Your Ref: OWPC20643
Our Ref: R/183/18/HH 01-08-2018
Please ask for:
Samantha Allen

Front ground floor extension, hip pitched roof extension to form 2 new bedrooms and bathroom in roof space with dormer extension to side, 2 velux windows provided in existing roof slopes.

8 Acre Close Rustington

Thank you for your internet representation made on 19th November 2018 which has been recorded as '**an objection**' with the comments as follows:

Amended plans for Mr. Mrs J. Edwards
at N°8 Acre Close Rustington to
planning application N° R/183/18/H.

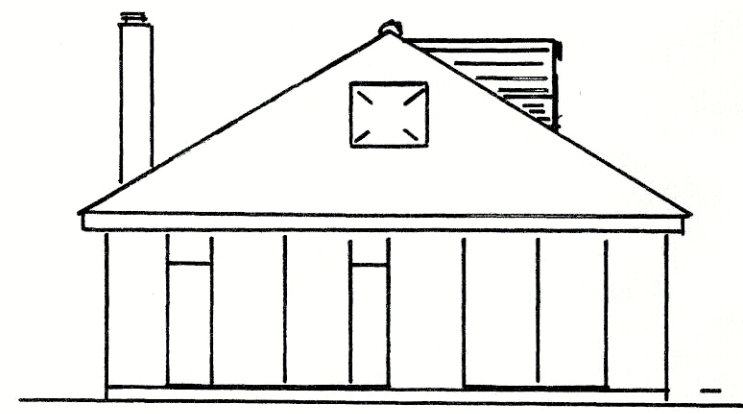
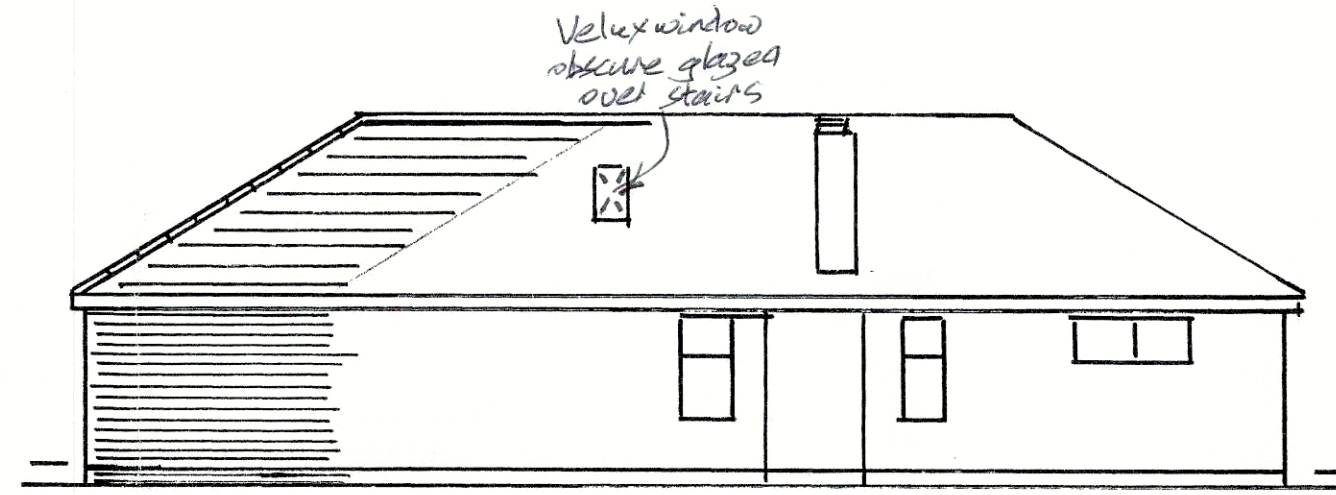
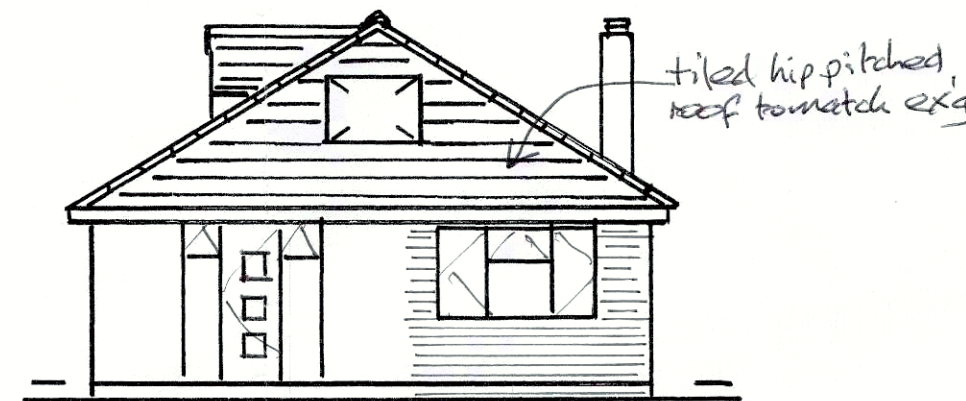
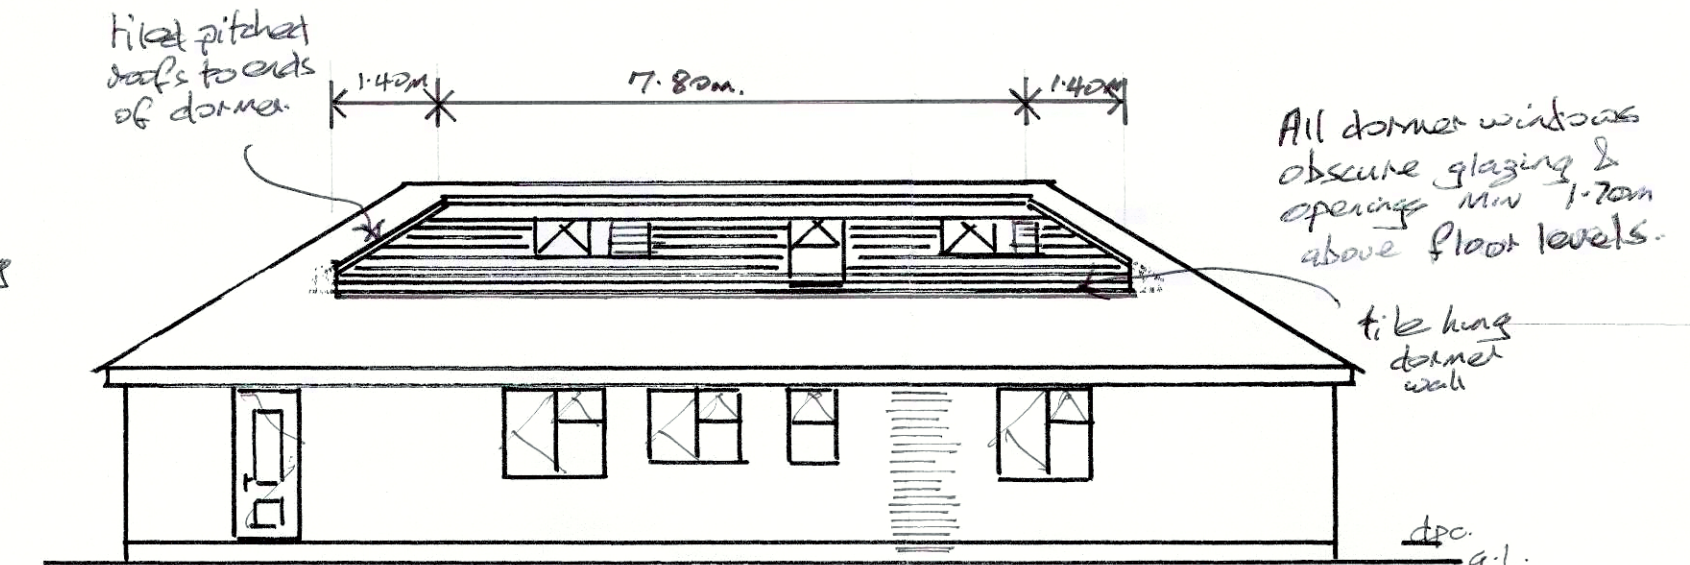
The proposed drawing amendment showing a hipped roof instead of a gable to the front elevation of 8 Acre Close does not change my objection to the scheme. Provision of a full length dormer complete with windows will seriously overlook my lounge window and rear garden resulting in loss of privacy currently enjoyed and not to mention totally out of place/unsightly in the Close of detached bungalows.

Regulations state that any upper floor windows located in a wall/roof slope forming a side elevation shall be glazed and non opening unless the parts of the window which can be opened are more than 1700mm above the floor of the room in which the window is installed - not as shown on drawings.
